Our Ref: **FP/233/11/**

16th December 2011

Front ground floor extension
28 Alfriston Close Felpham

DRAWING
PROPOSED ELEVATIONS
DATE: NOVEMBER 2011
DRAWN: T. Murray
DRAWING: 11/35/4

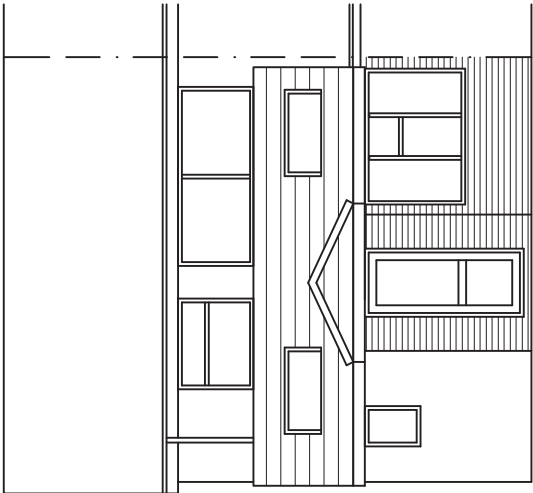
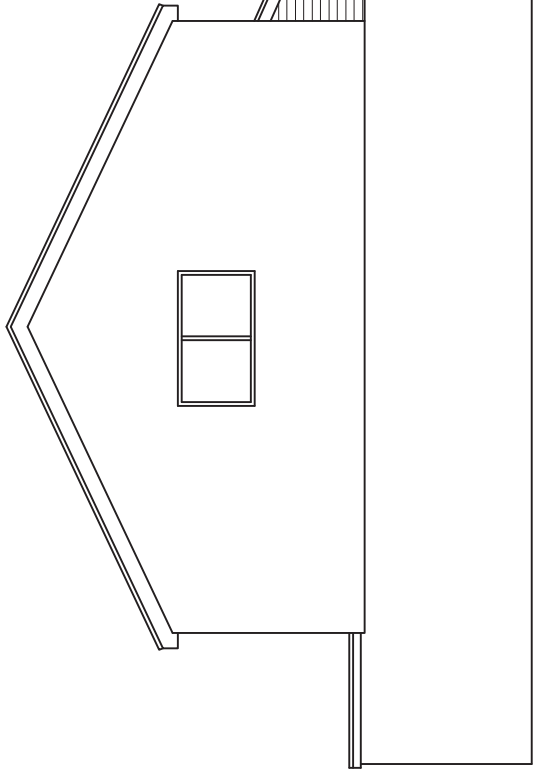
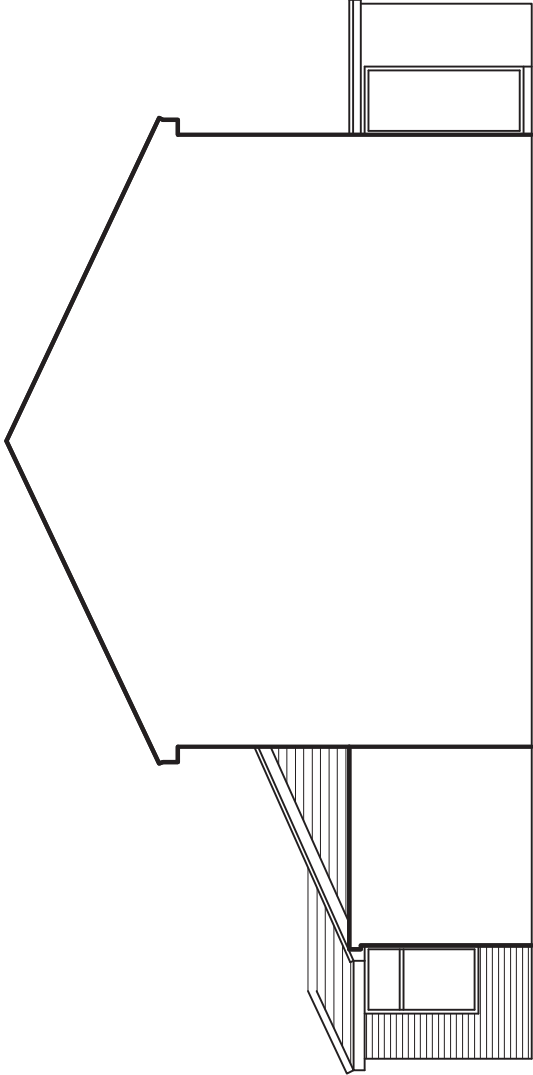
Please provide 1 electronic or 3 paper copies of revised proposed elevations as there is either a window or a door missing from the side elevation in accordance with the guidance notes available on our website detailed below (click on National List).

Please submit 1 electronic or 3 paper copies of a revised proposed roof plan to clearly show the rooflights in accordance with guidance notes available on our website detailed below (click on National List) **shown on revised pro elevations.**

28AlfristonClose

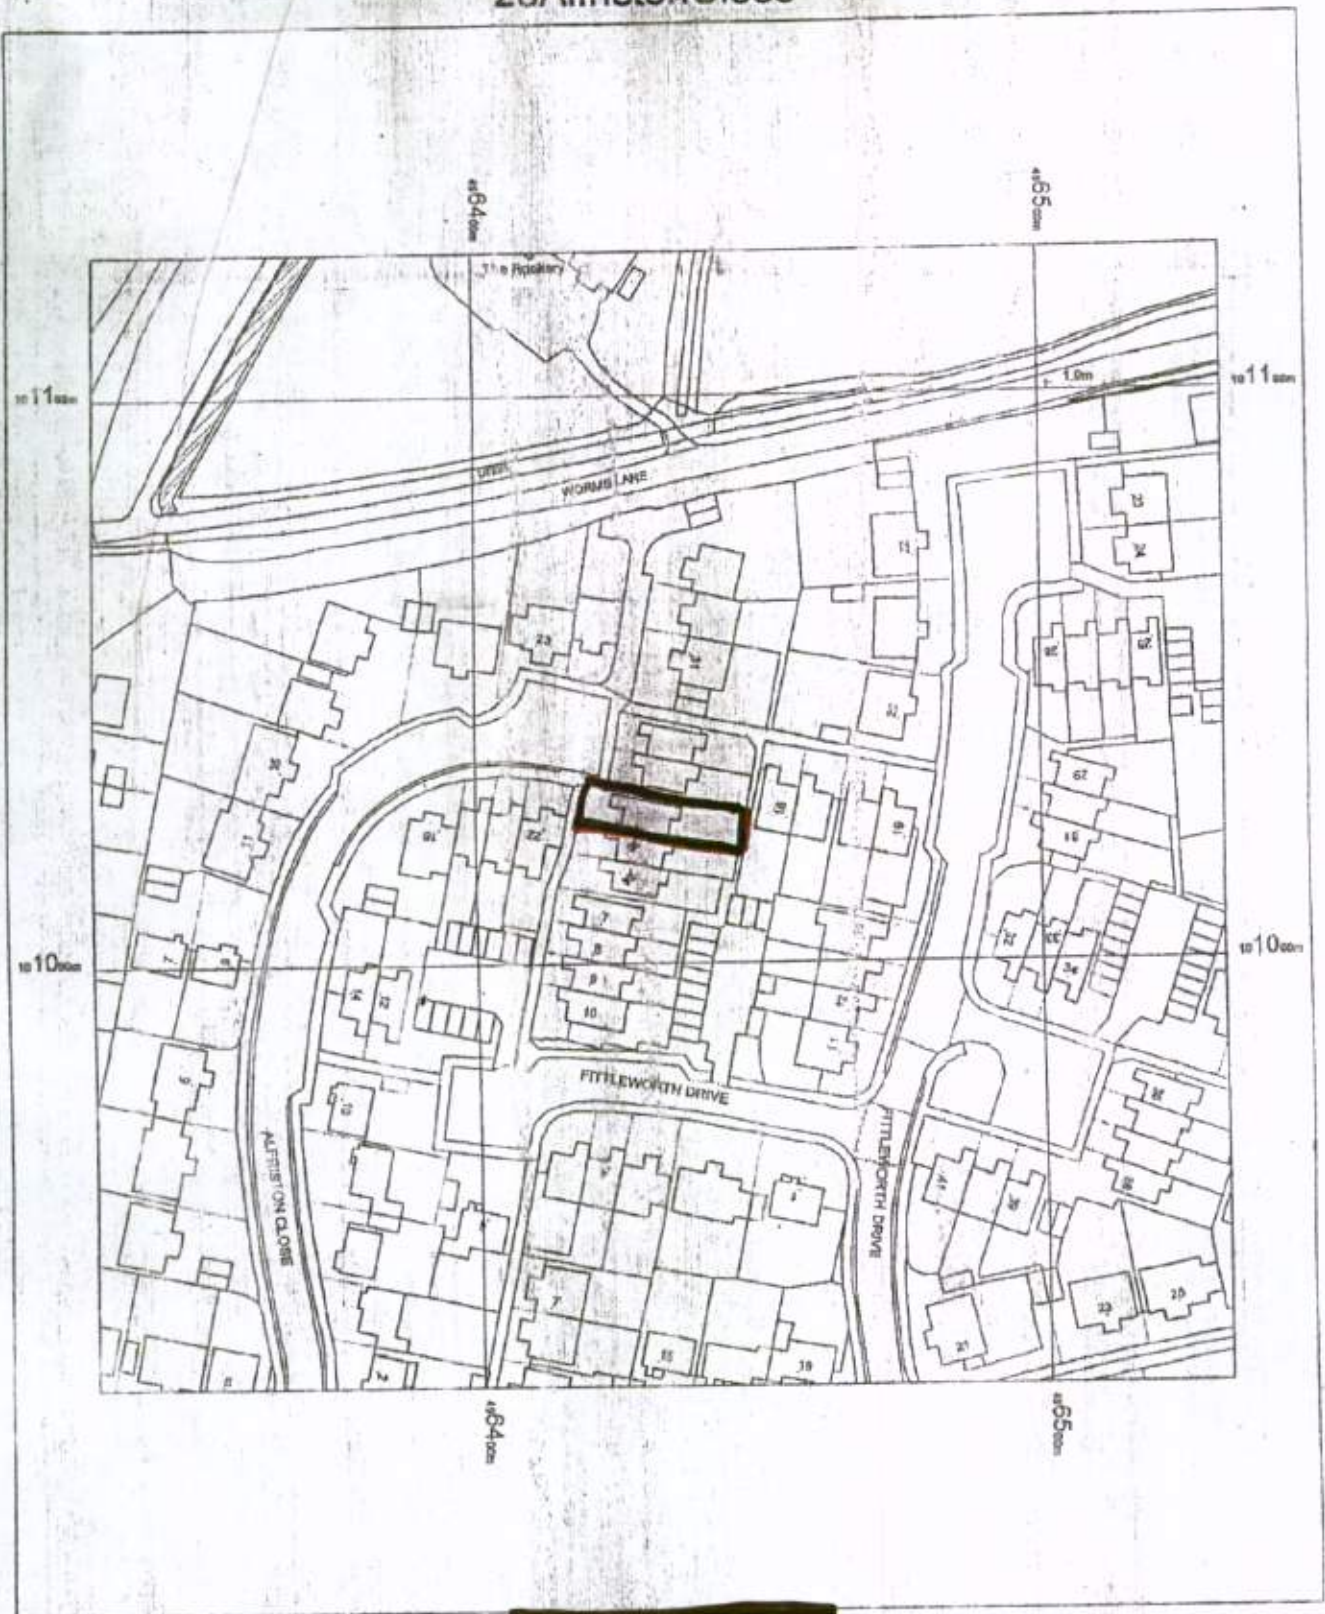
I require 1 electronic or 3 paper copies of a revised location and block plan as the plans submitted do not scale in accordance with the guidance notes available on our website detailed below (click on National List).
